29 May 2017

**NEW RESTAURANT AND MICRO-BREWERY
TENANCY 5, OVERSEAS PASSENGER TERMINAL, CIRCULAR QUAY
(SSD 7683)**

RESPONSE TO SUBMISSIONS

257_ADA_024_B

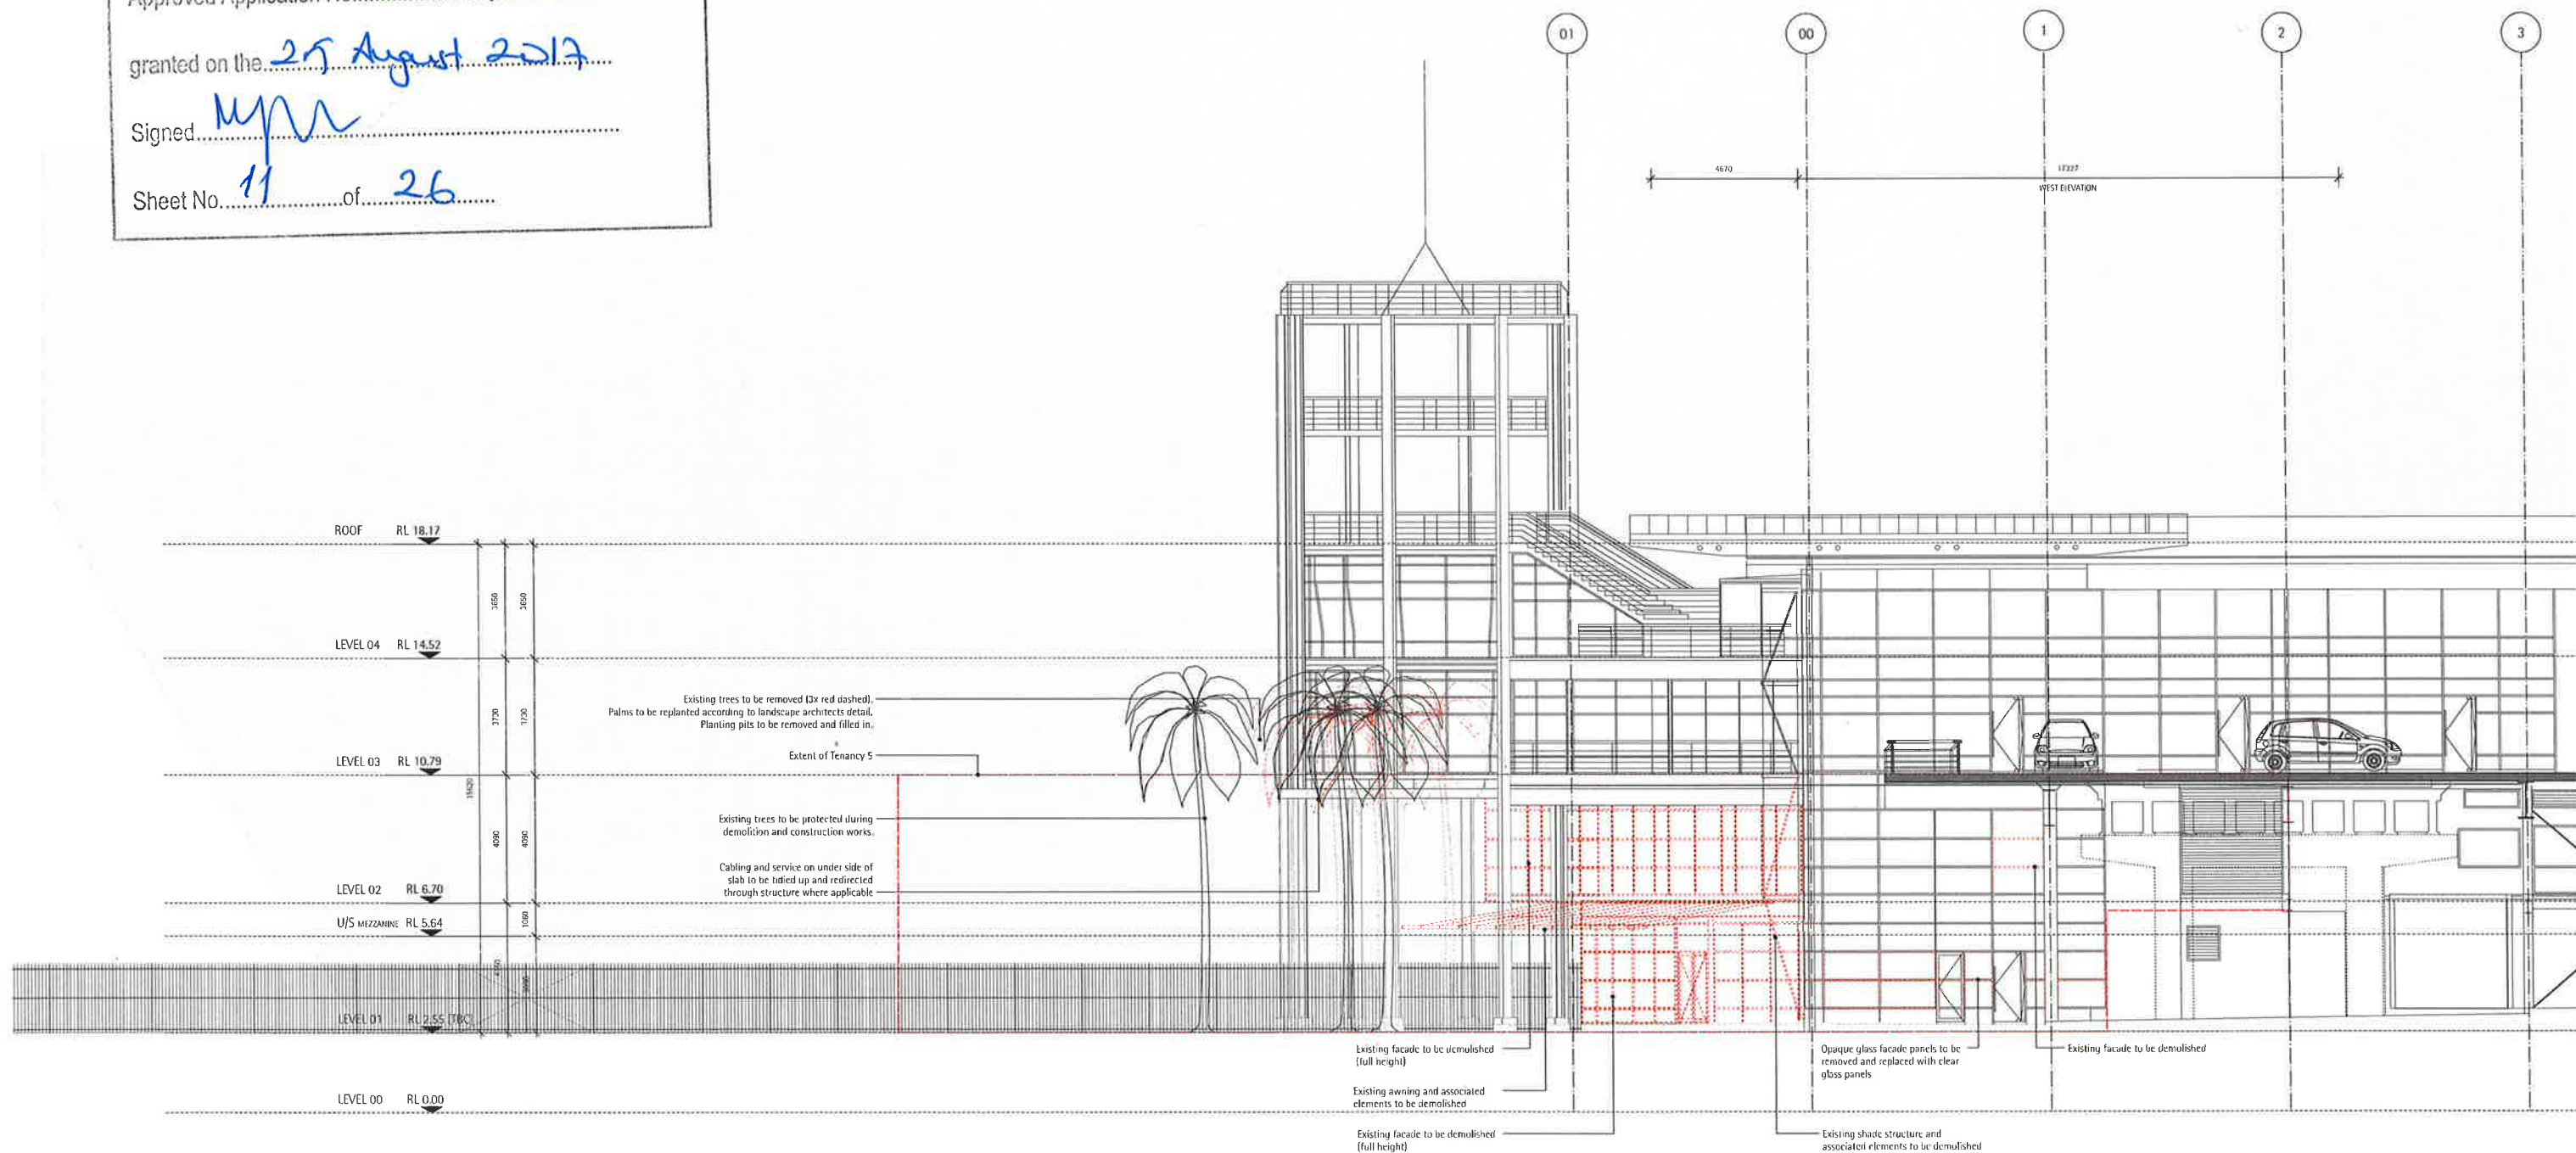
- *the notation on 257_ADA_024A regarding uncertainty of extent of demolition shall be removed from the plans or clarified;*
- *clarification of the materials to be used in the construction of the drums within the micro-brewery pod shall be noted on the plans;*
- *the relevant Finished Floor Level (FFL) shall be included on each plan;*
- *clarification is needed as to the abbreviation NMP and NIA on the plans;*
and
- *the sections shall be revised to include the extent of the proposed footings*

Updated and amended plans have been prepared by Collins and Turner (Attachment 2). This also includes amended SCRA drawings to support the amended proposal.

1 Brew-pod Elevation
Scale 1:50

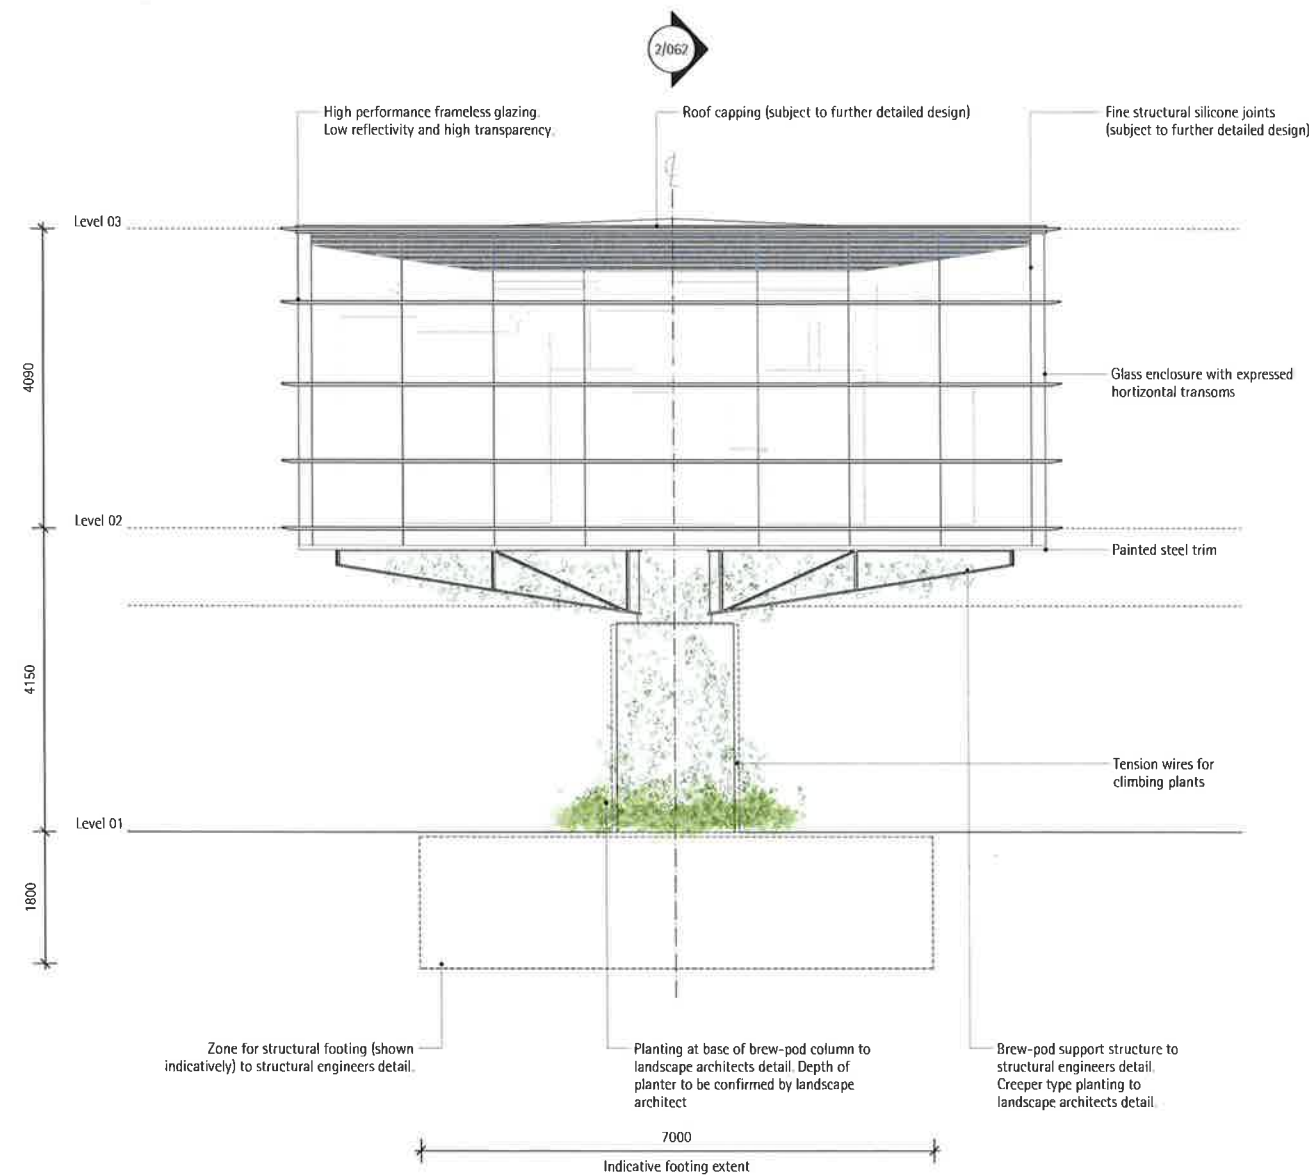
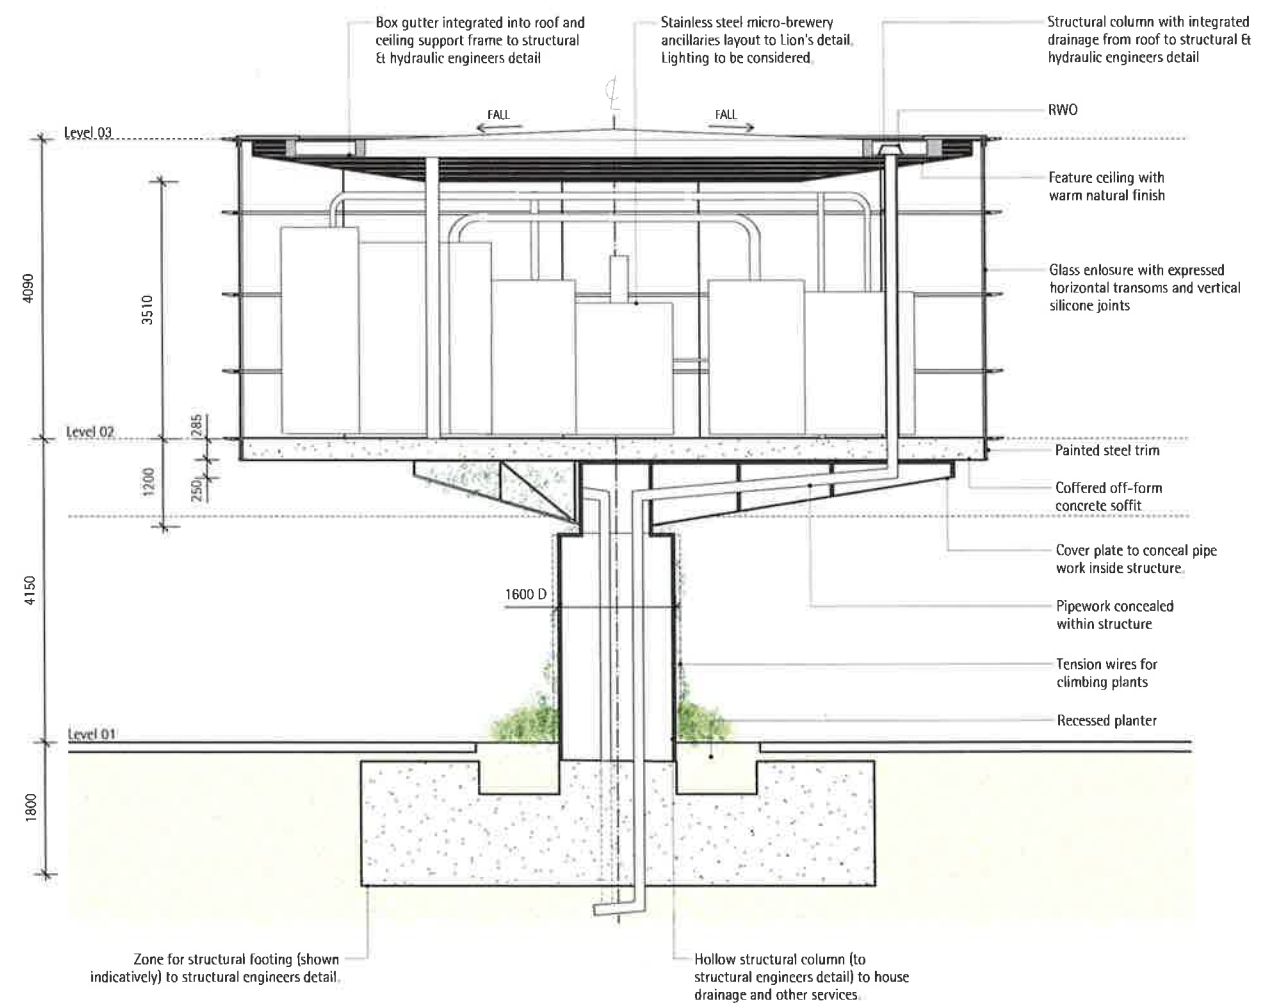
The Department has carefully considered the proposed location of the micro-brewery pod and in conjunction with the advice provided by Mr Peter Webber (Attachment B) wishes to advise it would result in significant visual and heritage impacts. Consideration of a more appropriate and sympathetic location having regard to visual and heritage impacts is therefore required.

consideration should be given to the proposed alternate siting and design of the micro-brewery pod in the RTS having regard to:

- *view impacts, which include a broader range of vantage points and those within the Sydney Opera House buffer zone;*
- *impacts on the public domain and landscaping;*
- *public access in and around the site;*
- *material selection; and*
- *access, maintenance and operation.*

The micro-brewery pod has been relocated to a more discreet location with reduced dimensions which significantly reduces any impacts on views, particularly to the Sydney Opera House. The revised pod design results in a reduction in the floorspace of 5m² and reduced side elevation of 5.2 metres from the original proposal due to its triangular form.

The pod has been carefully re-designed in a triangular form which better integrates with the form and character of the OPT. The revised design also maintains 3 of the existing palm trees, the other 3 palm trees relocated on the site.
